An  
Bord  
Pleanála

## Memorandum ACP-323024-25 – Request for Further Information

**To:** Stephen Rhys Thomas, ADP  
**From:** Peadar McQuaid, PI  
**Re:** 323024-25  
**Date:** 18<sup>th</sup> December 2025

Galway County Council is seeking approval from An Coimisiun to undertake proposed works to raise the elevation levels of local tertiary road (L-52214) at Cuan Na Loinge, Ceantar na nOileán, Co Galway. The length of road to be raised is approximately 200 metres. The maximum increase of road elevation will be of 1.0 metre above the existing road level, with natural rock armour embankments and natural stone parapet walls on each sides together with associated drainage, water services, fencing and signage. The subject site is proximate to Kilkieran Bay and Islands Special Area of Conservation (SAC) (Site Code: 002111).

NOTES:

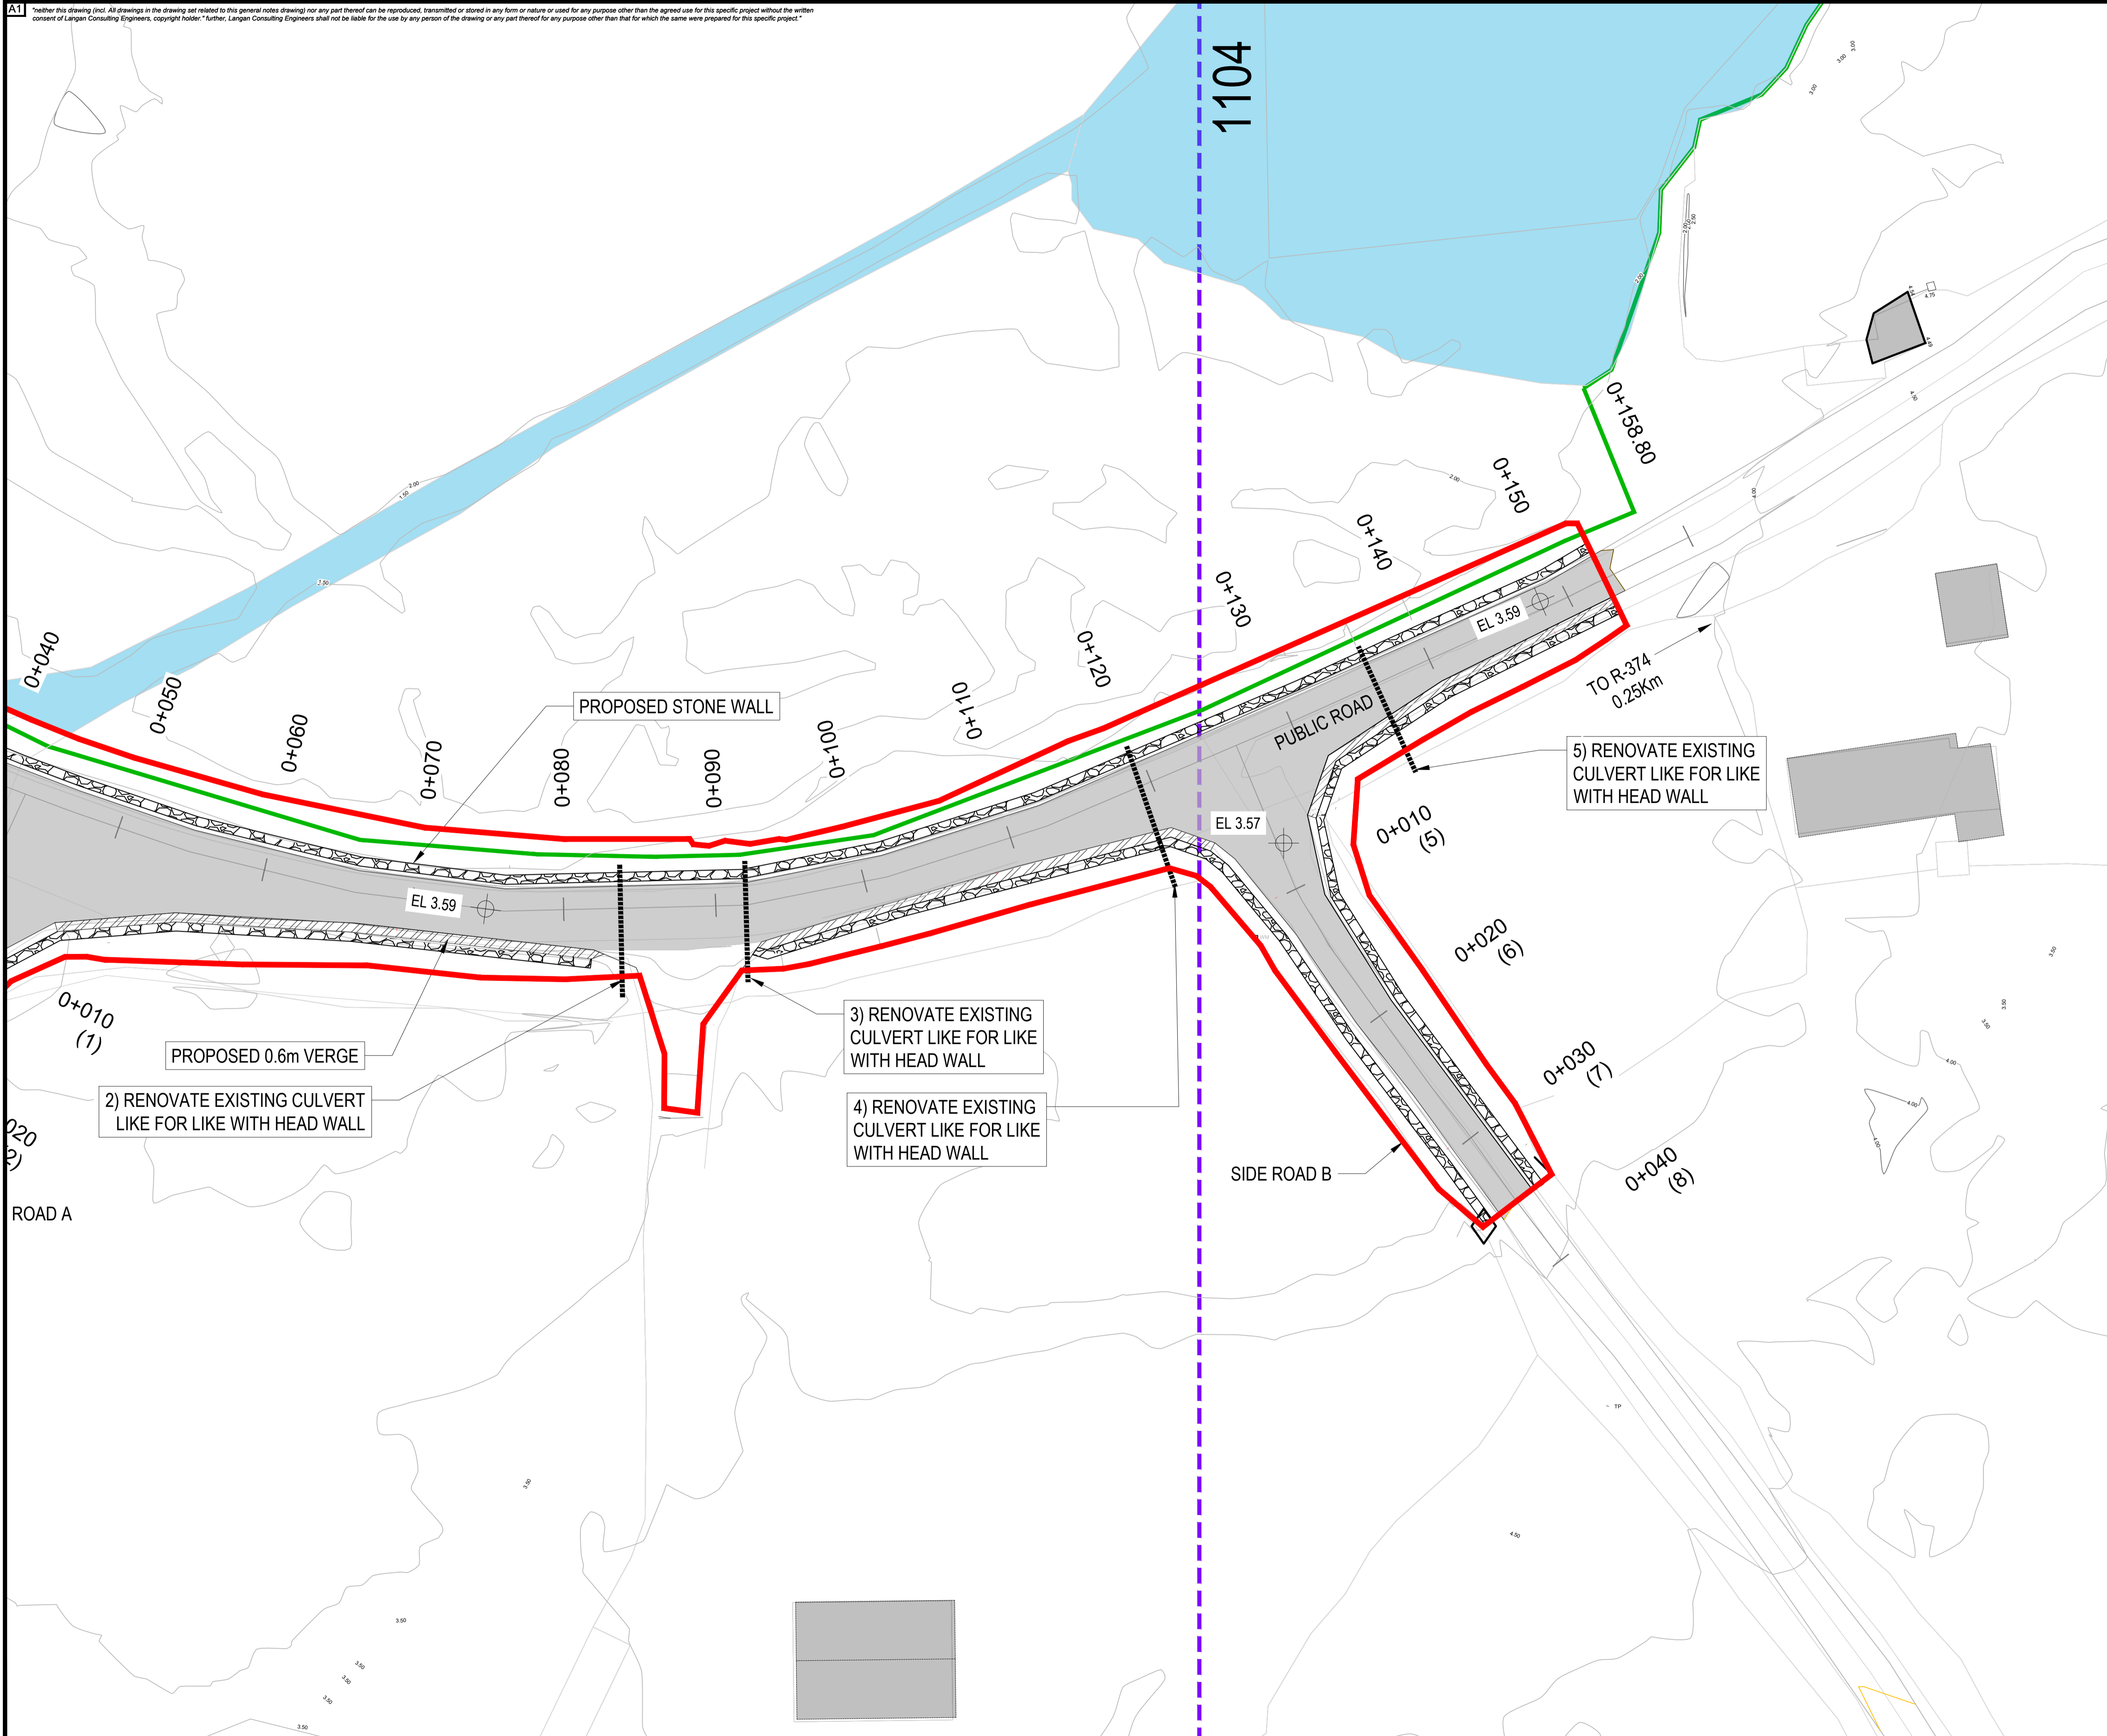
Conflicting information is presented within the Environmental Constraints Report and the NIS regarding the location of the proposed works. Based on the submitted drawings it would appear that the proposed works would encroach into the Kilkieran Bay and Islands SAC. However, this needs to be clarified by the applicant.

- iii. Habitats providing a supporting function to the annex habitat.
  - iv. Habitats of biodiversity value beyond the Natura designation(s).
2. Detailed drawings (1:200 scale) showing the footprint of the proposed works, the SAC boundary and confirmed Annex I habitats/non-Annex I habitats within the application site boundary.

ENVIRONMENTAL: SAC EXTENTS
PROPOSED TYPICAL ROAD RAISING CROSS SECTION A-A
SCALE 1:100

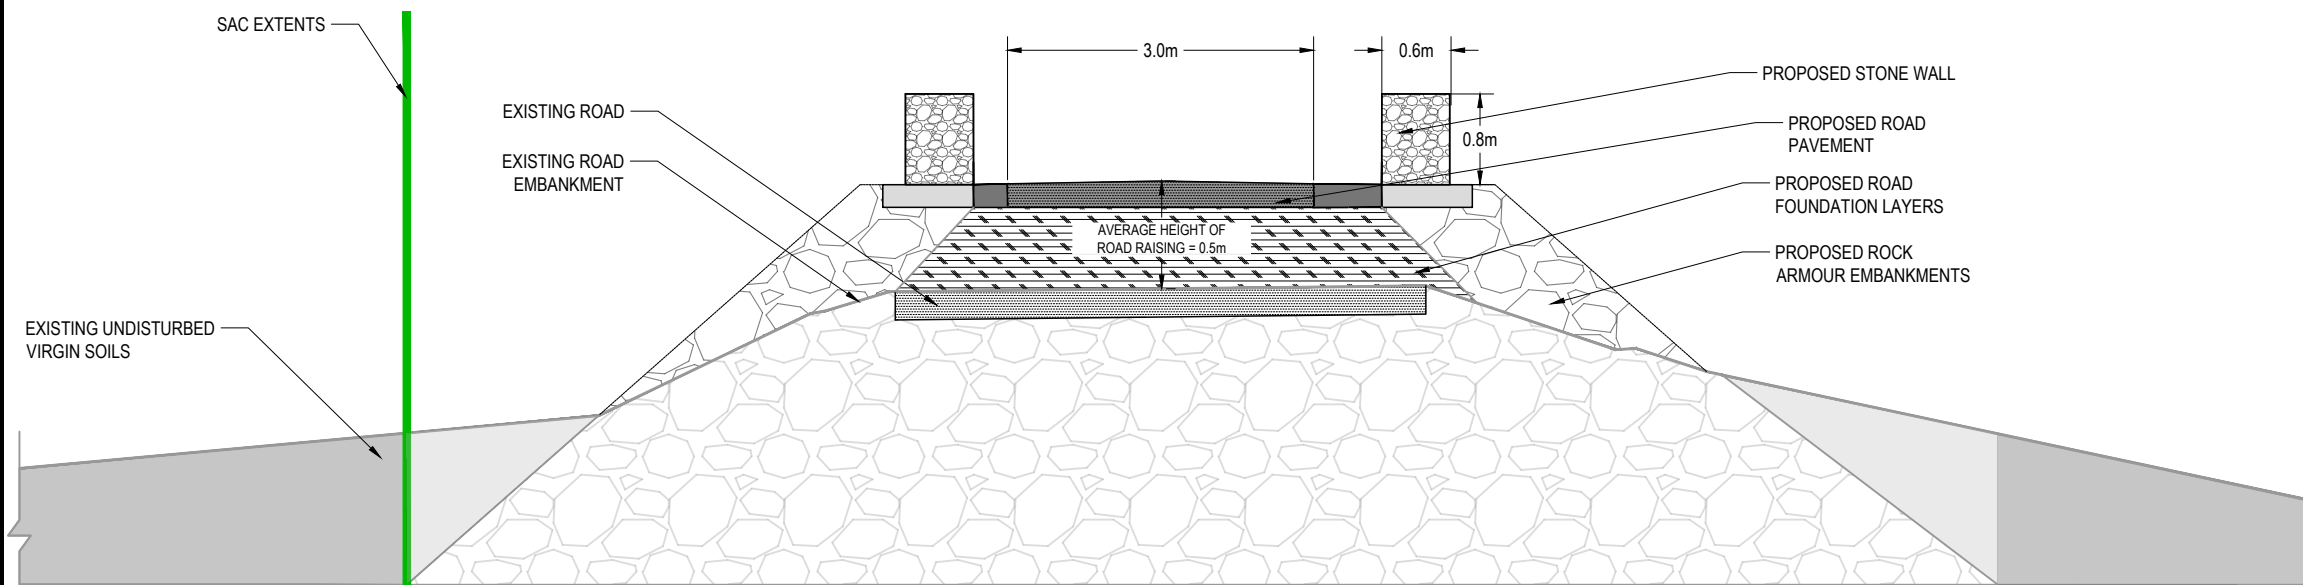
The Department has raised concerns in relation to the submitted NIS and the non-identification of Annex I habitat adjoining the proposed works. Furthermore, the Department has also queried the findings contained in the NIS with regards to possible habitat loss within the SAC. A cross-sectional detail drawing and diagram re-produced in the 'Preferred Scheme Option Report' indicates that a rock armour embankment is to be installed along the proposed elevated road which is significantly wider than the existing road which may result in the loss of Annex I habitat area (Coastal lagoons [1150], or Atlantic salt meadows (*Glauco-Puccinellietalia maritima*) [1330]).
